Riverside Energy Park

Applicant's response to Greater London Authority's Deadline 8b Submission

8.02.100

October 2019

Human Health Receptor Locations (elevated receptors or 'tall buildings')

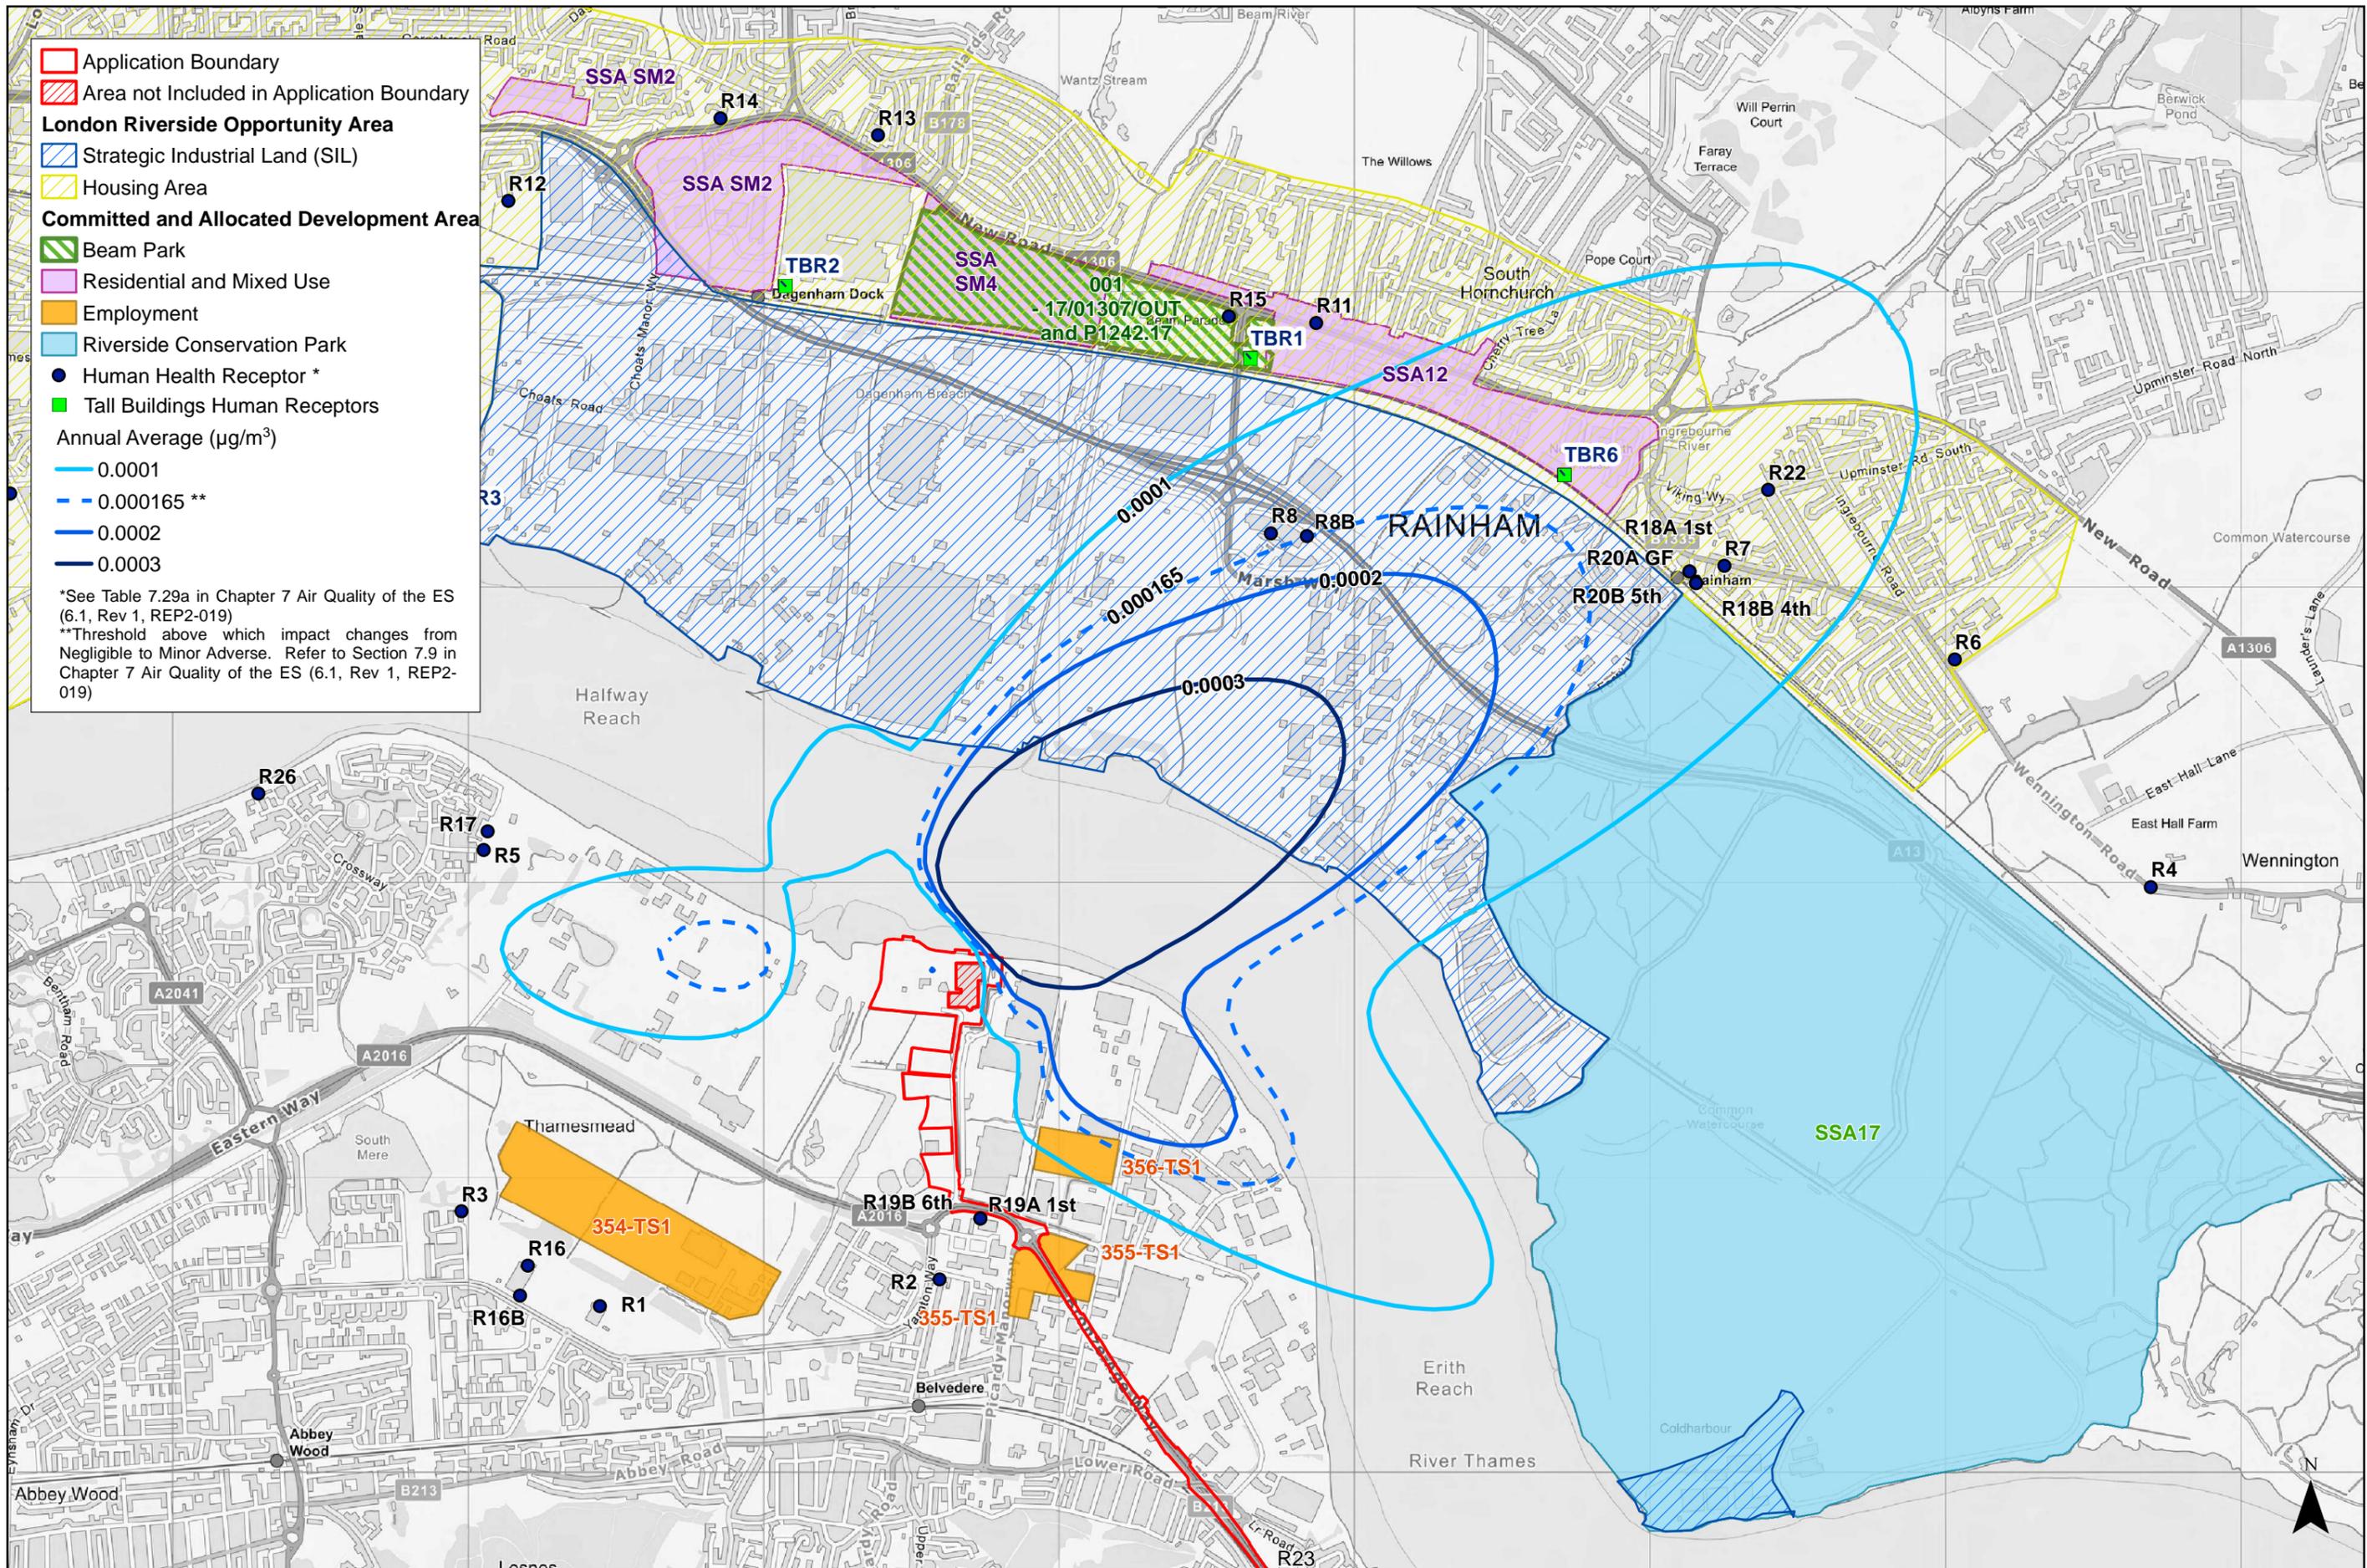
10e	<p>The Applicant has failed to take proper account of important changes in the future baseline including the prevalence of high-rise buildings in nearby Opportunity Areas (GLA Deadline 5, Schedule 1, paras. 68 –</p>	<p>The GLA has misunderstood the information provided in the Applicant's submissions. The locations of the tall buildings that have been assessed are numbered TBR1 to TBR6 on Figures 1a to 5 of the</p>

Paragraph Reference	GLA's Comment at Deadline 8b	Applicant's Response
	<p>77). The maps showing receptor locations and expected tall buildings were provided separately from the narrative description of the results and were provided as figures 1a to 5 of the Applicant's Deadline 7a submission "Applicant's response to Air Quality Matters (with track changes)." Assuming that the maps are correct none of the receptors (R1 to R6) relied upon to demonstrate "negligible" impacts are located within the Beam Park Opportunity Area, indeed only R4 and R6 are even on the same side of the river. Receptor R15 was relied on by the Applicant as representative of potential tall building locations within the Opportunity Area, and the map shows that this is indeed located close to a potential tall building site (TBR1). However, this location is well outside the expected centre line of the pollutant plume whereas TBR6 is almost in the centre of the plume. TBR6 has not been modelled or assessed.</p>	<p>Applicant's response to Air Quality Matters (8.02.70, REP7a-002). These locations are the same as the receptor locations numbered 1 to 6 (apart from the prefix 'TB') that are included in Section 6.1 of the Applicants Response to the GLAs Deadline 3 submission (8.02.35, REP4-014). In particular TBR1 is located in the eastern end of the Beam Park Opportunity Area closest to the expected centre line of the plume. The impacts at TBR1 and TBR6 are included in Table 6.1 of the Applicants Response to the GLAs Deadline 3 submission (8.02.35, REP4-014) and it is therefore not correct to suggest that the impacts within Beam Park or at receptor TBR6 have not been assessed. As shown in Table 6.1 and discussed in Paragraphs 6.5.16 to 6.5.23 of the Applicants Response to the GLAs Deadline 3 submission (8.02.35, REP4-014), all of the impacts at tall buildings are not significant.</p>
